CITY OF ALBUQUERQUE

May 16, 2024

**Re: Burger King
3221 Coors Blvd. NW
Traffic Circulation Layout
Architect's Stamp 4-10-24 (G11D003D)**

Based upon the information provided in your submittal received 4-12-24, the above referenced plan cannot be approved for Building Permit until the following comments are addressed:

## TRAFFIC CIRCULATION LAYOUT

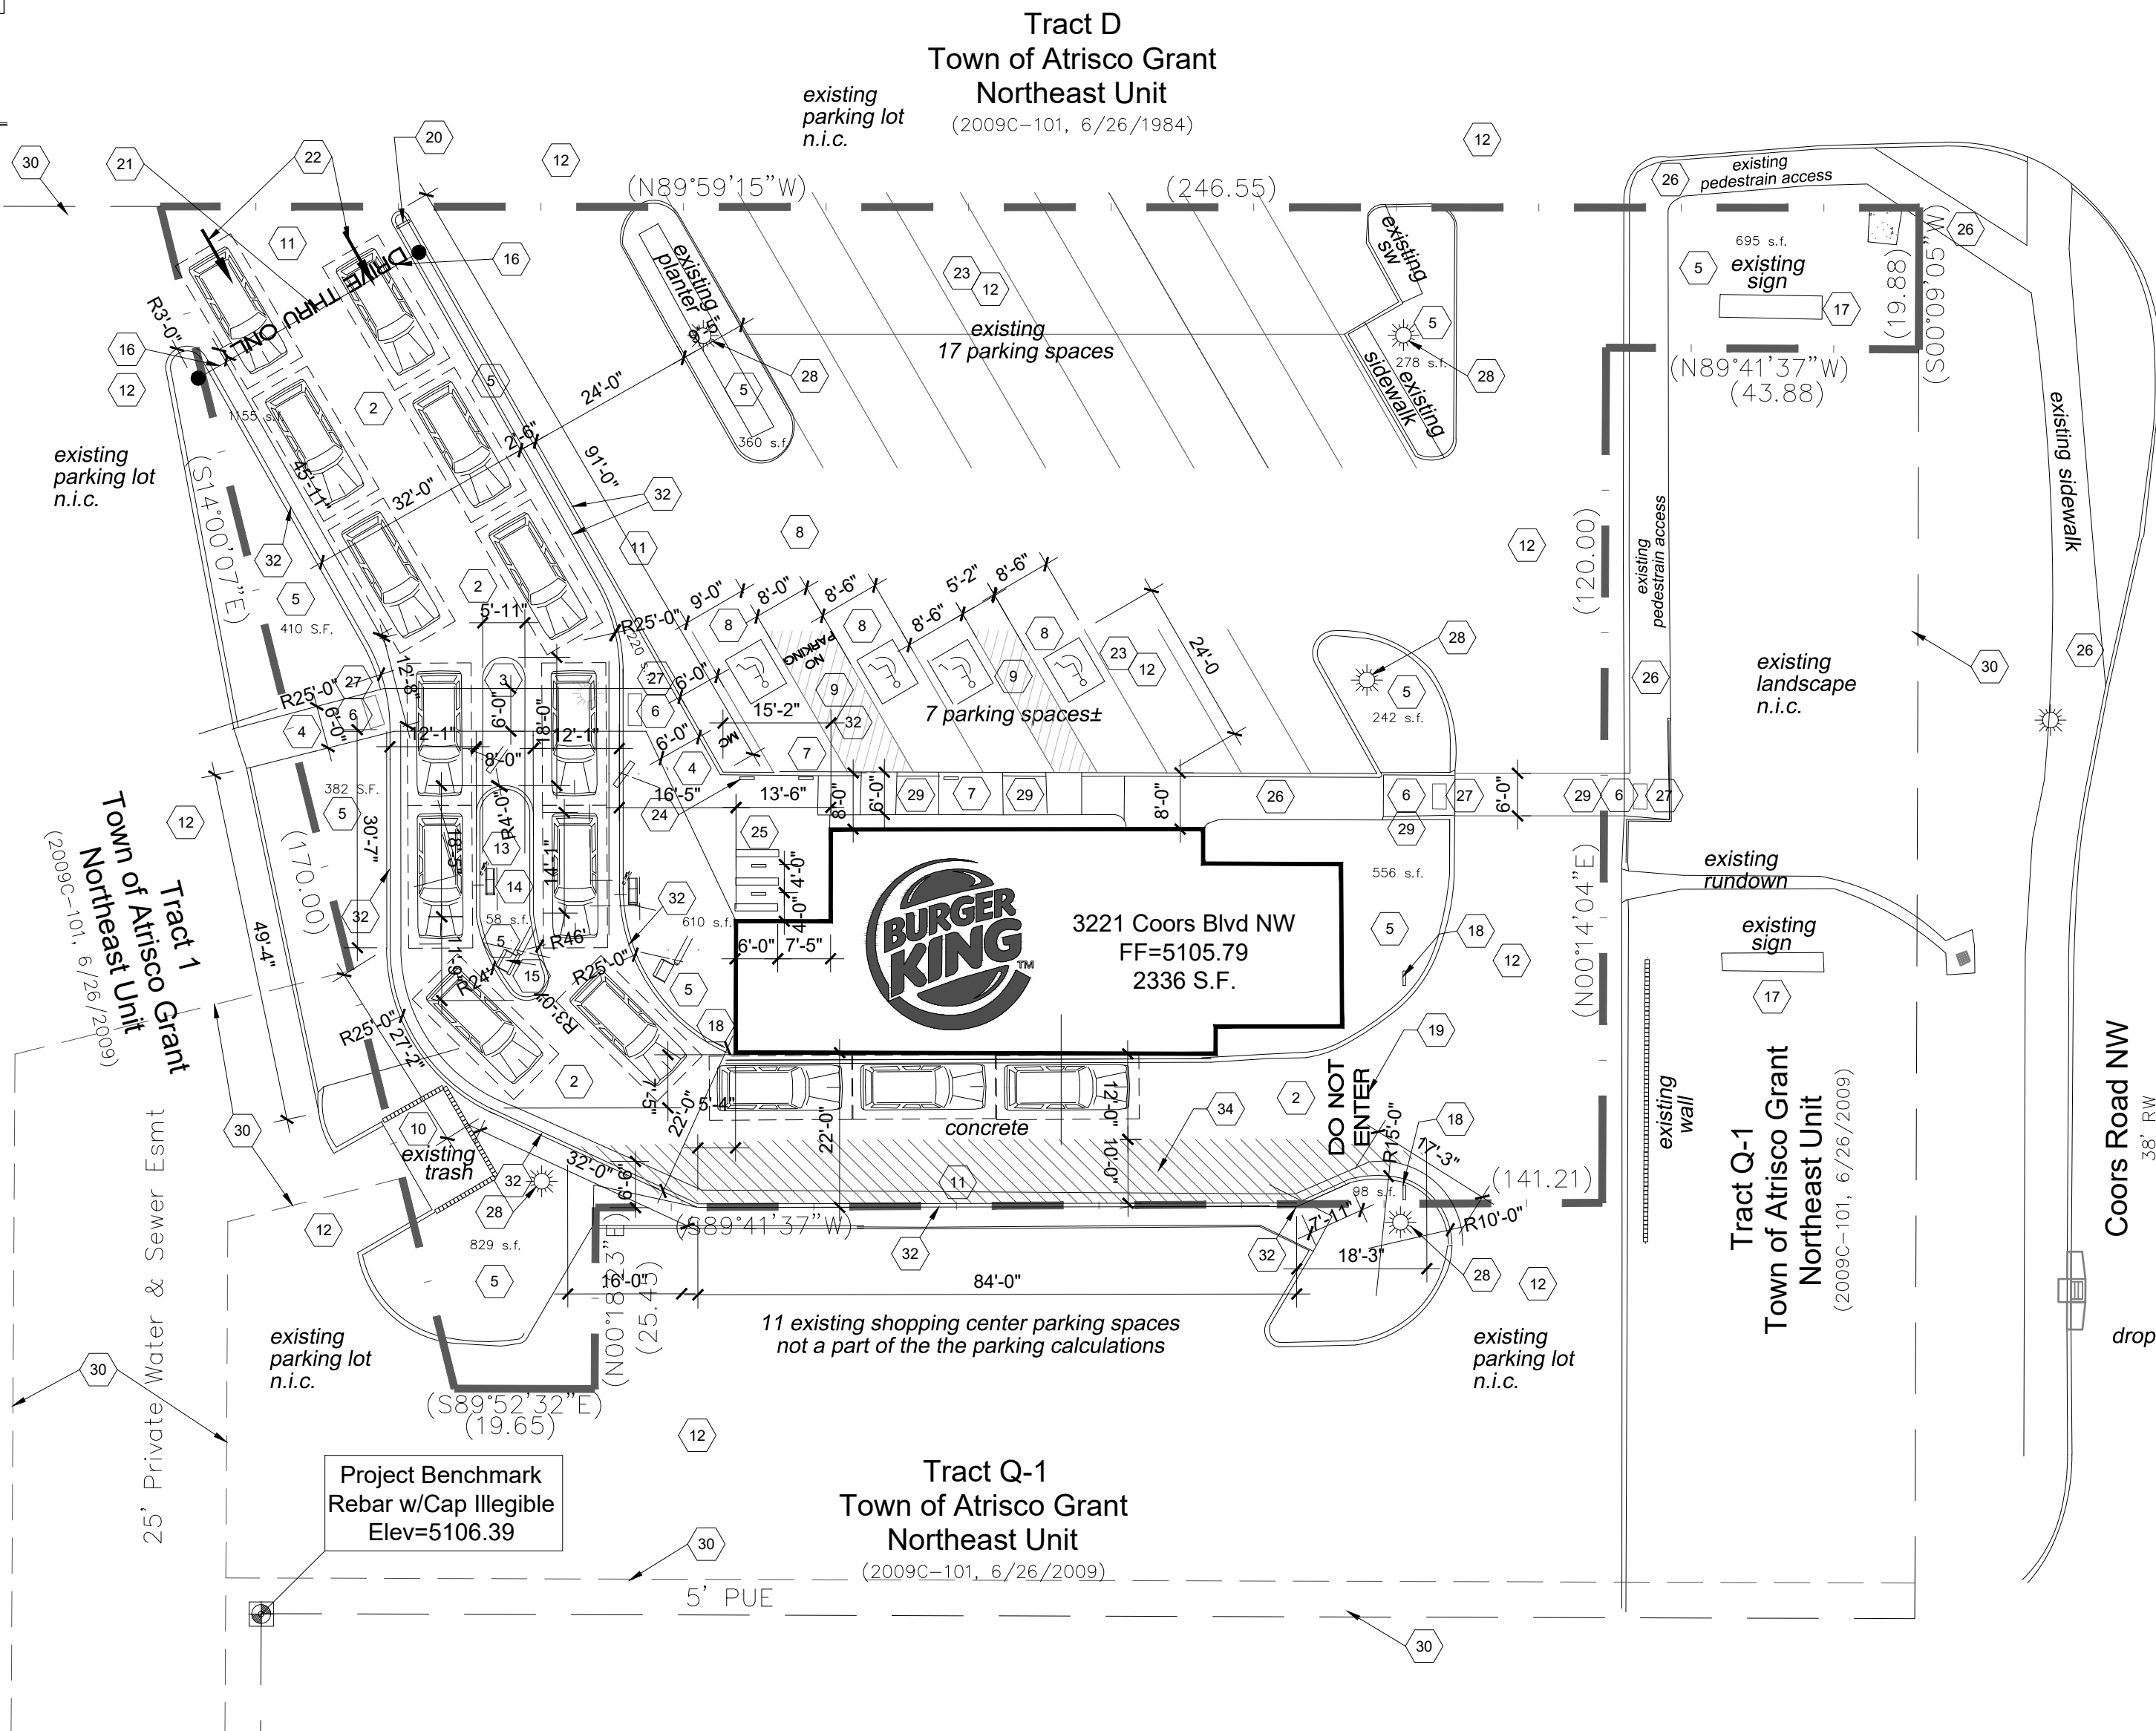
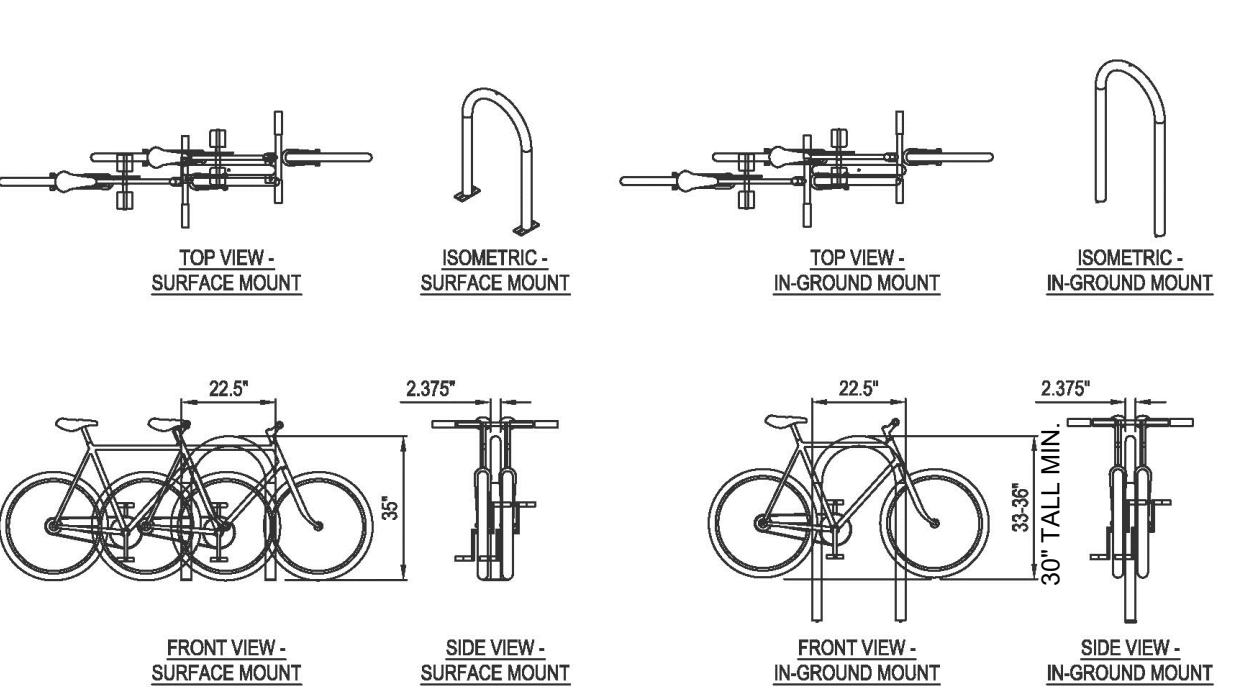
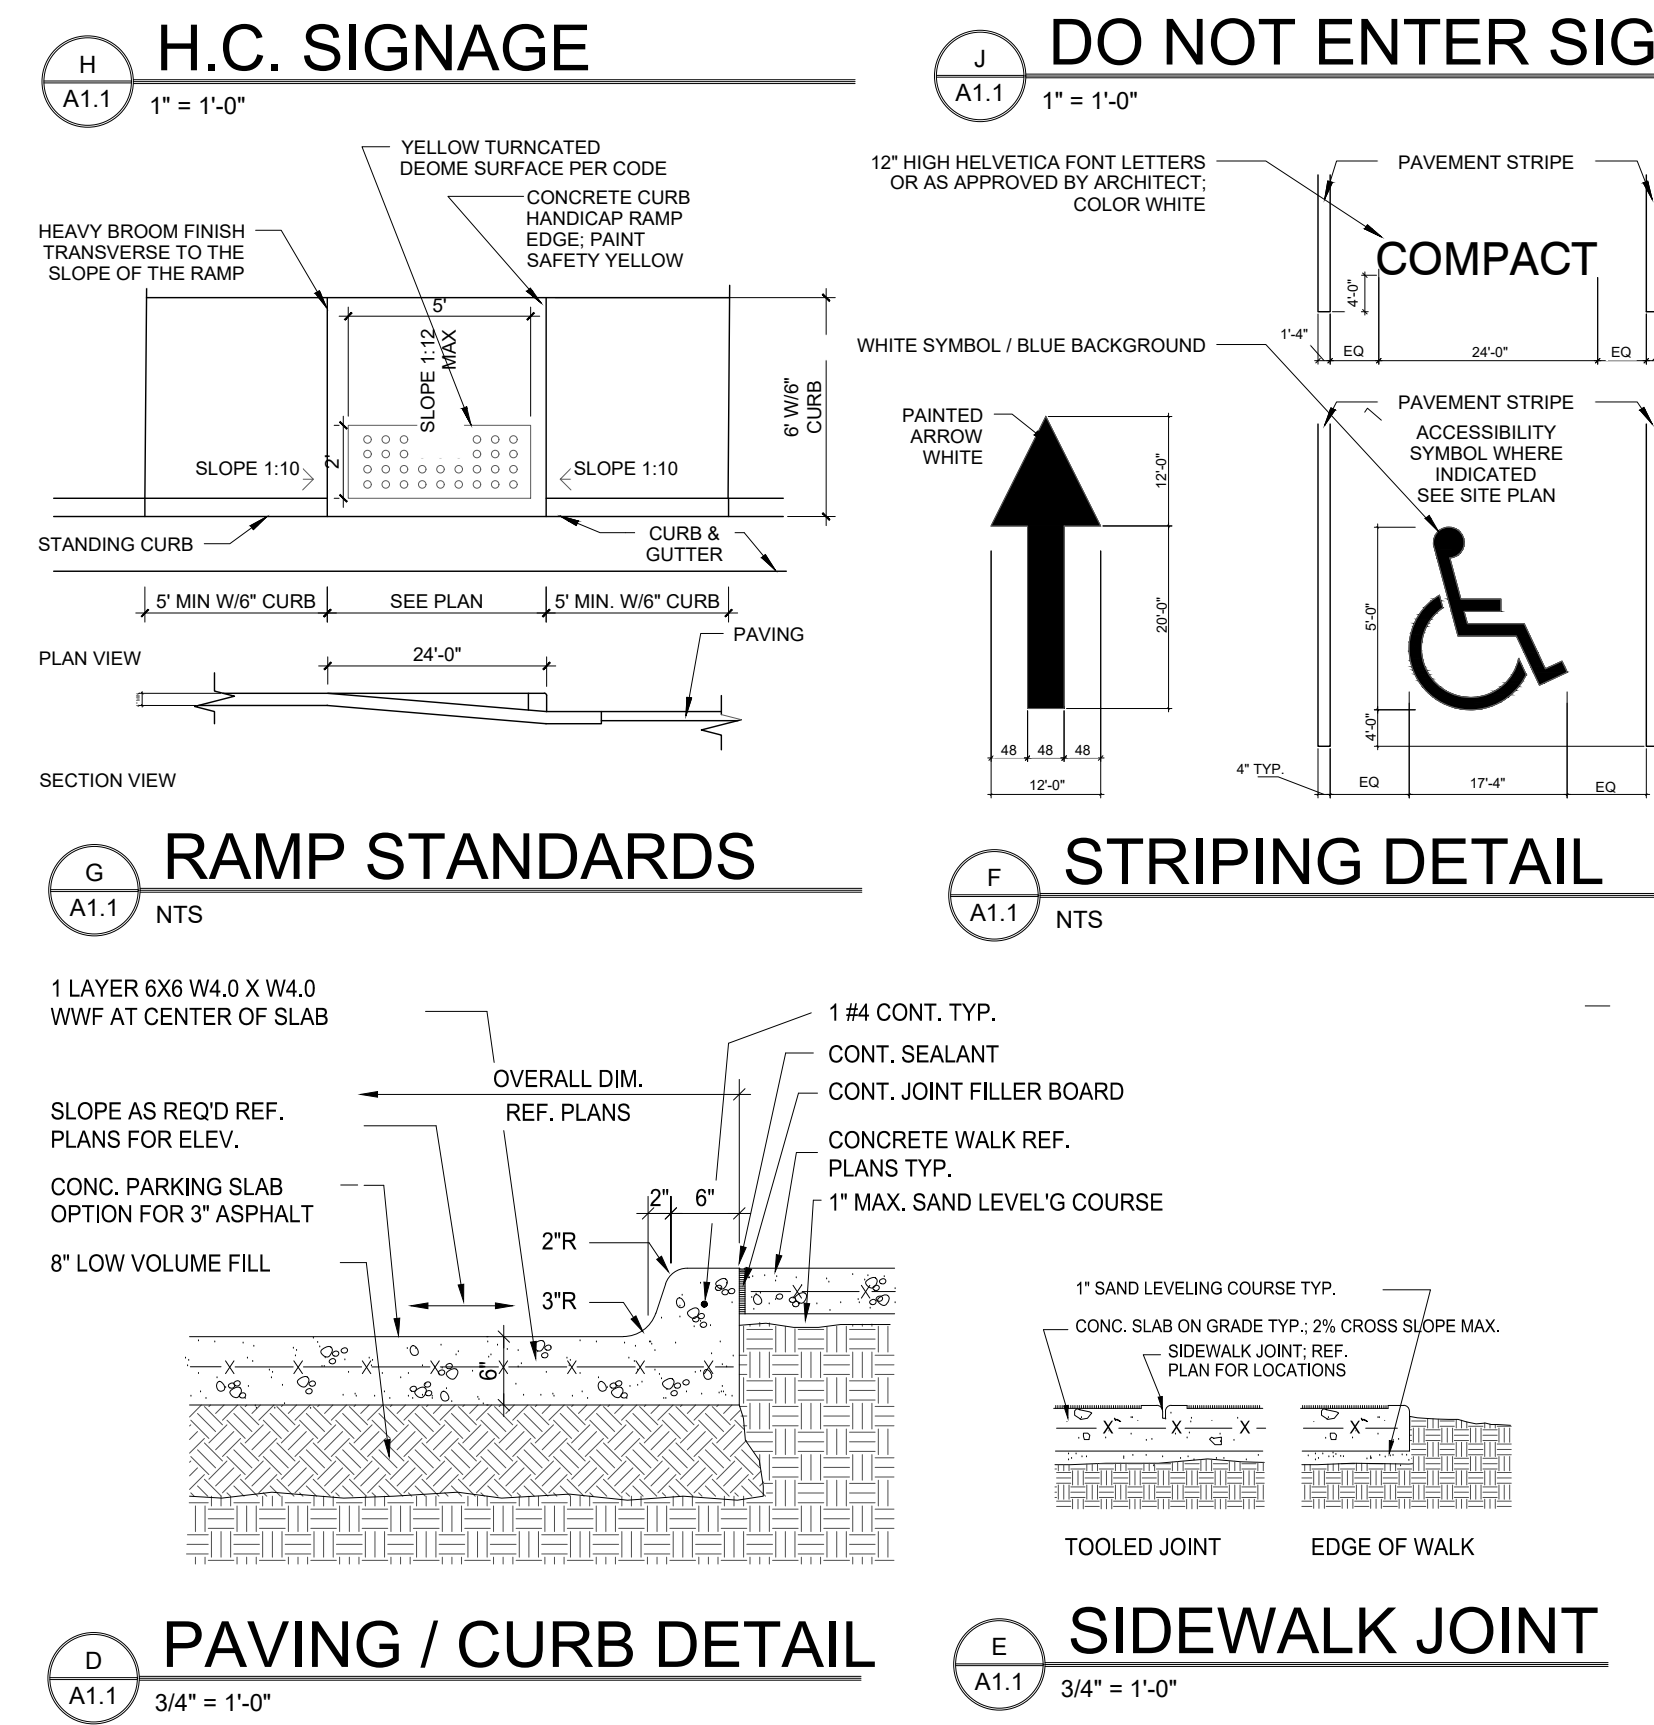
1. The minimum number of bicycle parking spaces is 3. Please update the parking table.
2. The ADA path from Coors Blvd red stamped concrete across the drive aisle appears to be broken in places. It does not appear to meet ADA and should be replaced

3. Please update the accessible parking signs ("Violators are Subject to a Fine and/or Towing").
4. Keyed Note 9: Please add the color blue and provide a detail or ANSI 502.3.

5. Keyed Note 8: The State of New Mexico's and the City's (white symbol/blue background) requirement may be different than ANSI 703.7. Please revise Keyed Note.

6. Keyed Note 7: It is not clear that ANSI 502.6 meets State of New Mexico and City of Albuquerque requirements. Provide the standard or a detail.
7. You need at least one van accessible aisle and sign. Provide a Keyed Note and a detail or appropriate information. Show the 8' minimum dimension for the accessible van aisle and the 5' minimum dimension for the other accessible aisle.

8. H.C. Signage detail- minimum height for the bottom of the lowest sign is 60".
9. Minimum size for motorcycle parking is 12"x18". MC parking spaces are a minimum of 4' wide. Please add a dimension.

10. Show the existing accessible ramps on the plan. If not to current standards add a note to replace.
11. Ramp Standard F/A1.1 This appears to be a black symbol. See comment 5 above and revise as necessary.

12. Provide dimensions for parking spaces to be restriped.
13. Keyed Note 6. I recommend adding the word "max" after 1:12.

14. The minimum radius for a drive-thru lane in the DPM is 25', unless the drive aisle is 14' wide, then the radius can be 15'. The plans shows 24' and 20'.
15. Add a Keyed Note for the new curb.
16. I see Keyed Note 25 and what appears to be symbols on the plan for bike racks. Please add a Keyed Note 25 in the location of the bike racks.
17. Bicycle Rack Detail: (a) racks are to be a minimum of 30" tall, (b) there is to be 4' between racks (to count as 2 parking spaces), (c) the parking space is 2'x6' per bike with a 1' buffer. This entire area is to be on concrete (it appears the racks are too close to the landscaping (d) Note 2 specifies installation per manufacturer, but the City requires them to be in concrete.
18. Add a Keyed Note 18 on the north side of the drive aisle.
19. What color is the striping south of the building?
